1 September 2020

Powerhouse Parramatta SSSA Reflectivity Response to Submissions

This letter is in response to submissions raised as part of the public exhibition of the Powerhouse Parramatta State Significant Development Application relevant to the Reflectivity Report, PHM-ARP-REP-FA-0003 (Arup, April 2020).

Figure 1: Map of ferry's travel path showing turning circle where east facades cast solar reflections above 500 Cd/m²

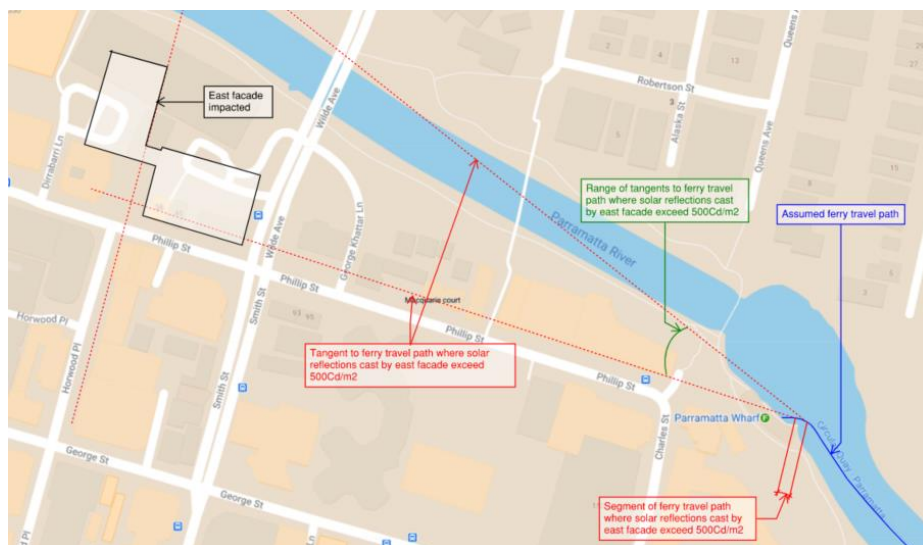
Provide further analysis and mitigation options for any reflectivity impacts on ferry operations.

The ferry approach on Paramatta River (Figure 1) has been reviewed for reflectivity impacts on ferry operators using the analysis method as for road traffic. Due to the limited exposure, the Reflectivity Report PHM-ARP-REP-FA-0003 noted that reflections are not expected to result in unacceptable glare towards ferry operators in this location. The below records additional considerations of mitigating factors and extent of reflection exposure to provide further context.

Viewed from the river, the east facades can potentially briefly cast solar reflections above the 500 Cd/m² threshold towards ferry operators (Figure 1). This only occurs at the ferry's turning circle, i.e. when the ferry turns to dock at the wharf (Figure 2). For the ferry travel path assumed, this is an approximately 8m stretch of the ferry's travel path (Figure 1). For the majority of the ferry's travel parallel to the river, the reflectance is below the 500 Cd/m² threshold (Figure 3).
